CITY OF ALBUQUERQUE

RE: Anasazi Ridge, Unit 3 (File: A10D002G)
Drainage Report, Engineer's Stamp Date 1-12-2015
Supplemental Rundown Calculations, Engineer's Stamp Date 2-3-2015
Grading and Drainage Plan Engineer's Stamp Date 3-4-2015

Based upon the information provided in your submittal received 3-5-15, the above referenced plan is approved for DRB action on the Preliminary Plat with the following comment:

*Tract A Pond / Channel
Spillway /Channel Vizcaya Avenue*

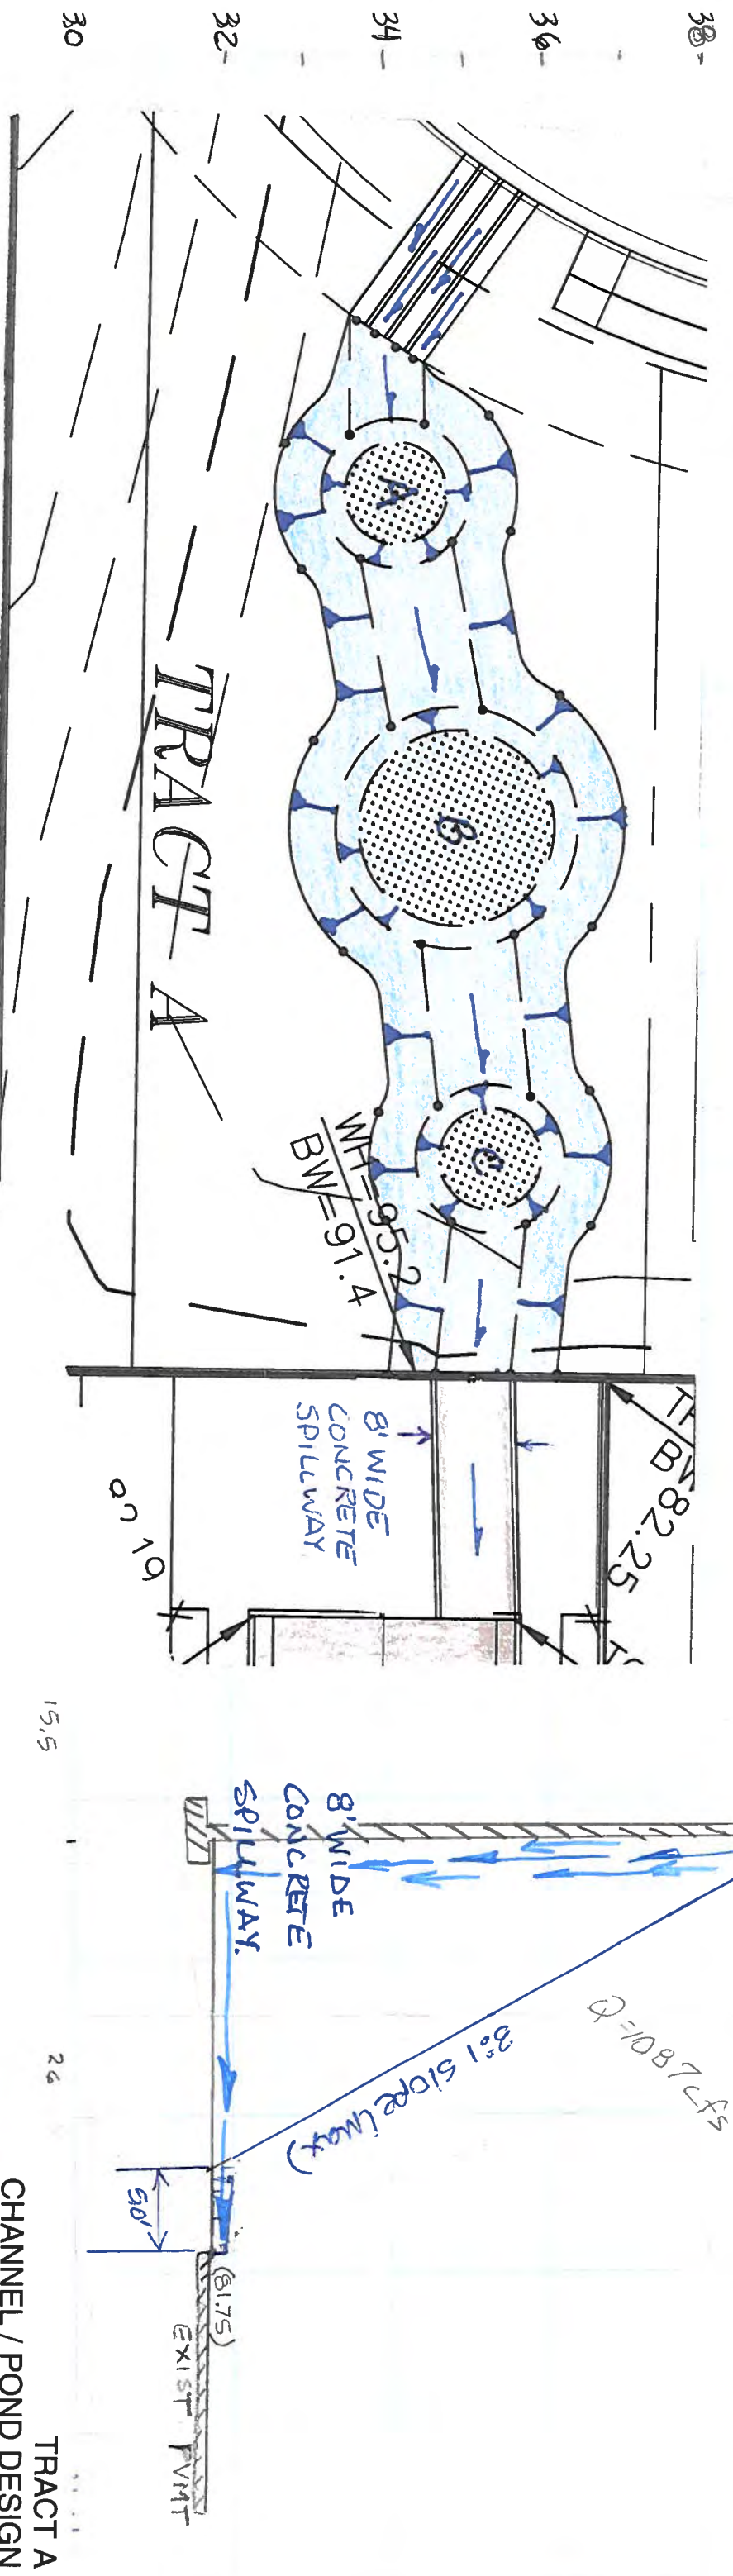
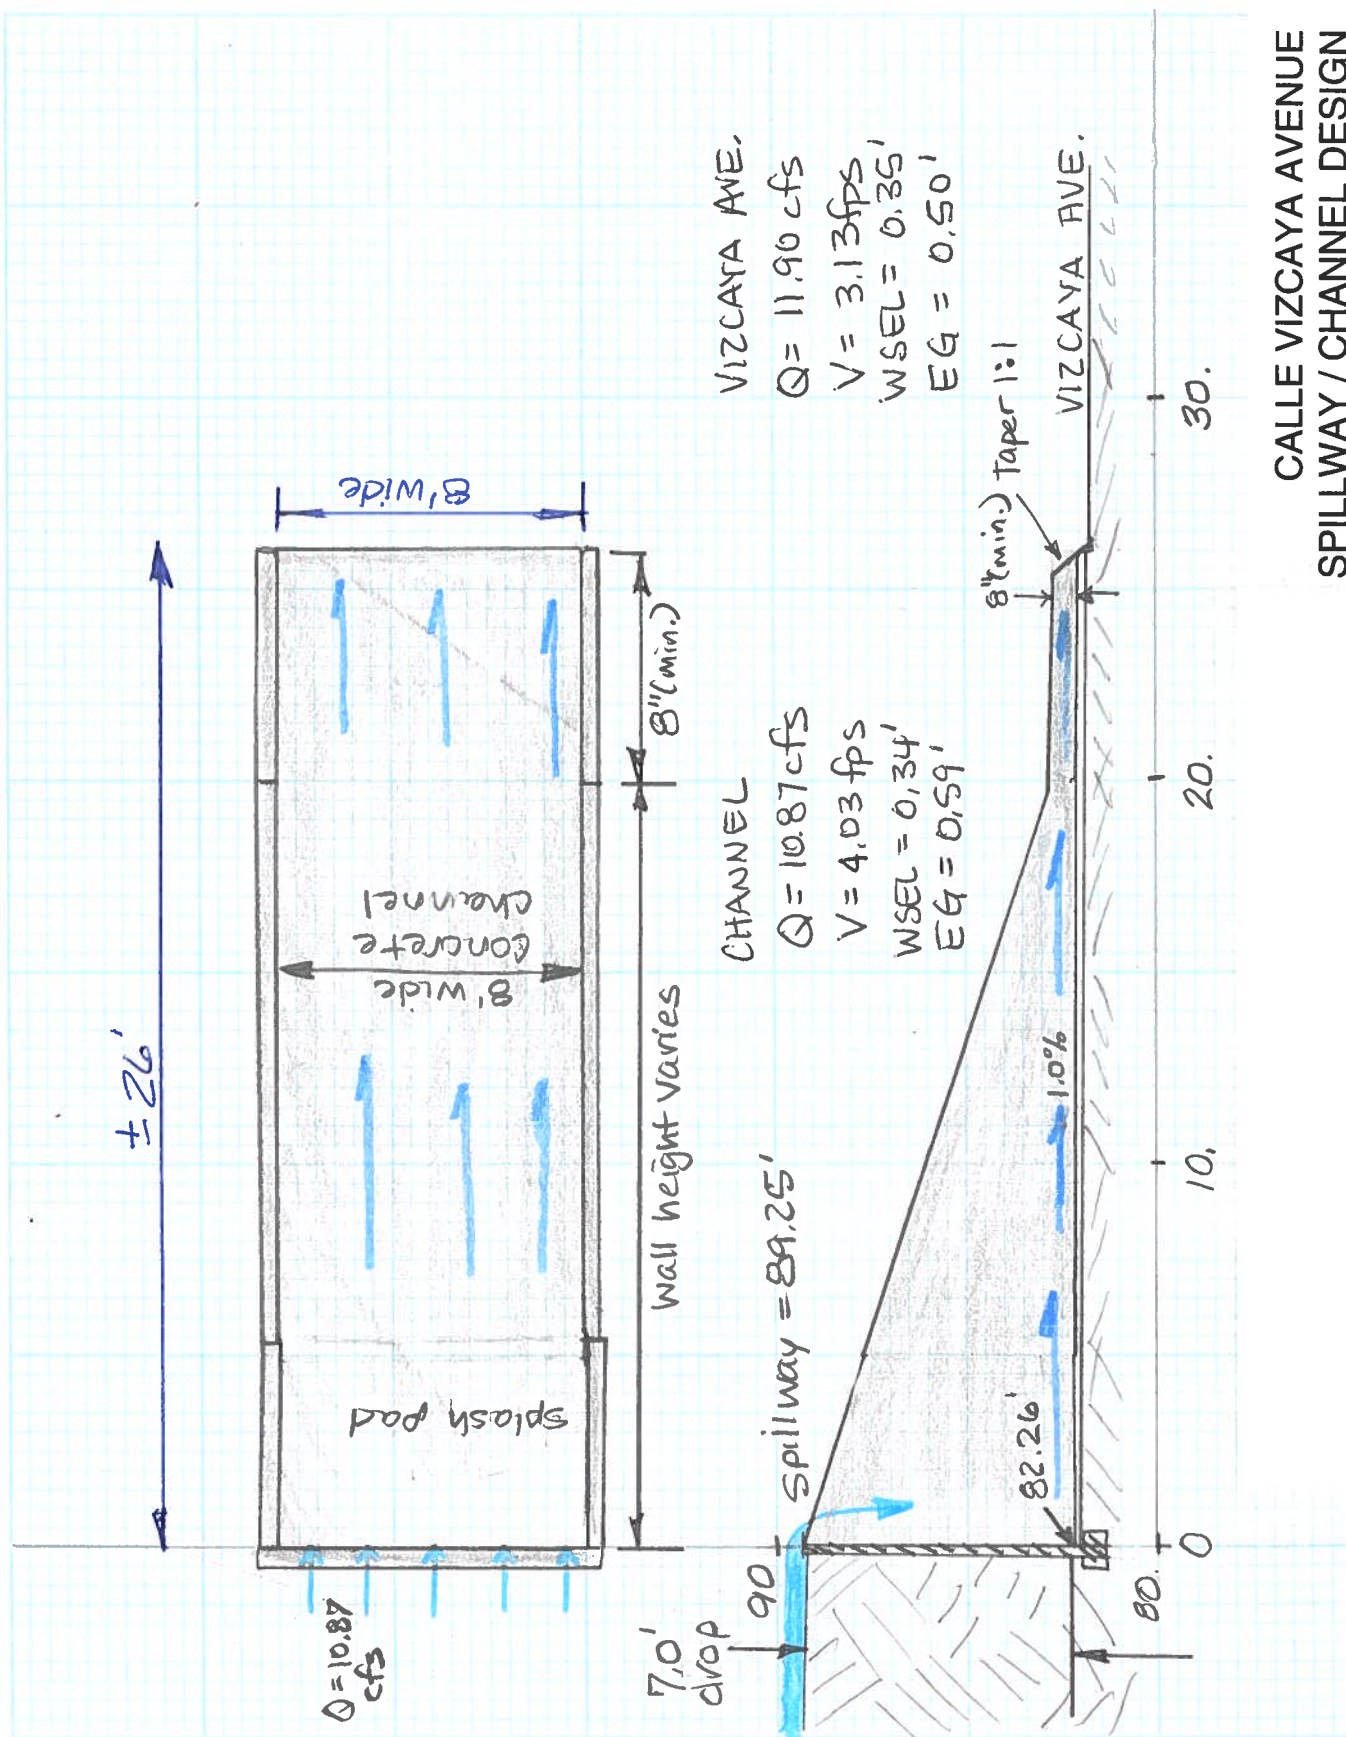
- It is understood that Tract A, B, and C have been incorporated into the adjacent lots. Remove the Tract labels on the Engineer's Certification plan.
- Ponds and channel sections in the public drainage easements on lots 23-P1 and 16-P1 need to be included in the Work Order Construction set.
